Application No: AW/353/20/OUT
Site Address: Land adjacent to 1 Cambridge Walk Aldwick PO21 5RL
Description of works: Outline application with some matters reserved for 1 No. new dwelling.

Thank you for your internet representation made on 26th March 2021 which has been recorded as an objection with the comments as follows:

Site Plan shows area bounded by: 491668.61, 99621.47 491810.03, 99762.89 (at a scale of 1:1250), OSGridRef: SZ91739969. The representation of a road, track or path is no evidence of a right of way. The representation of features as lines is no evidence of a property boundary.

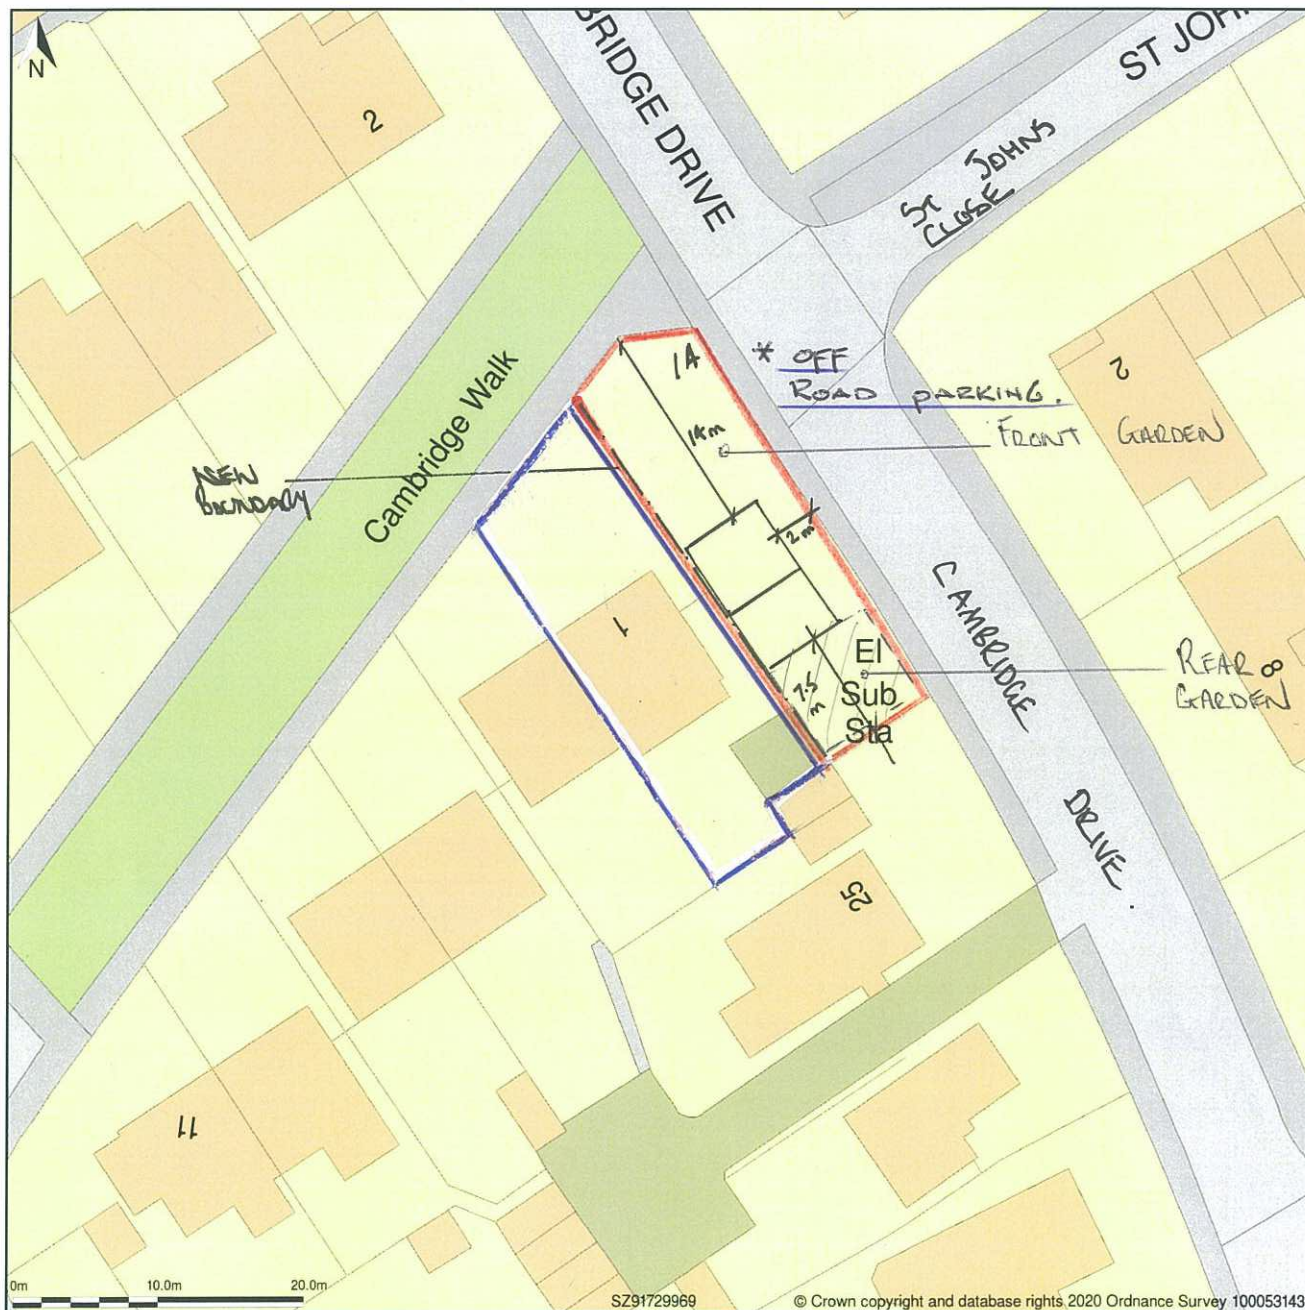
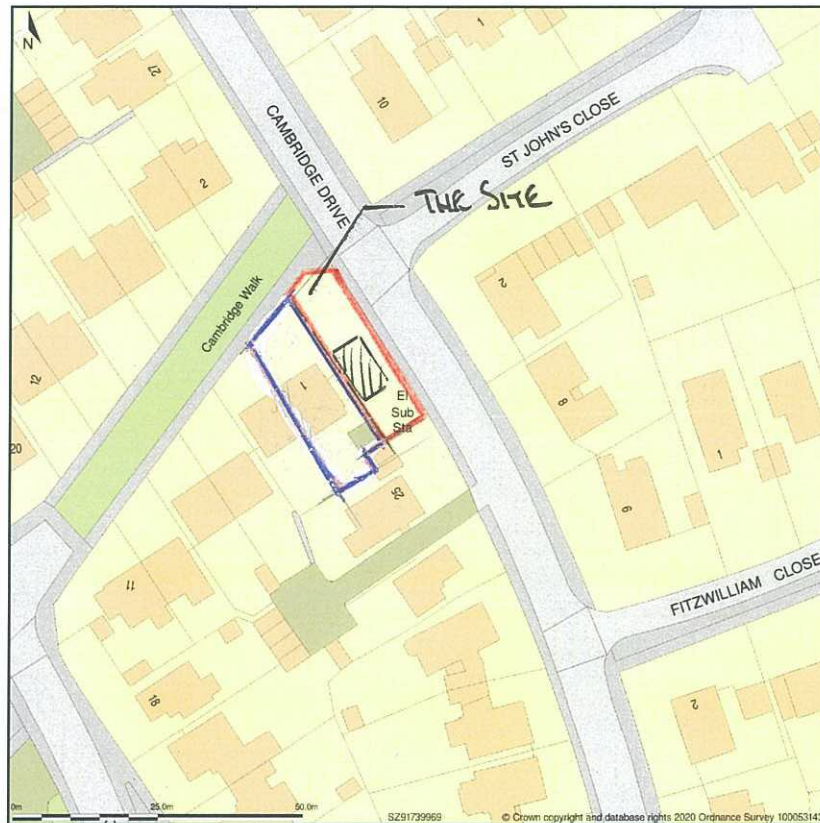
I am dismayed that someone is attempting to build on this piece of garden. There is a large sub station on the site which needs access and a large tree, both of which do not seem to feature in the submitted design. All of the dwellings in that area are bungalows, this property would be completely out of keeping with the area. The building seems very close to the boundary line, which I thought was a breach of planning regs. Please do not let this development go ahead.
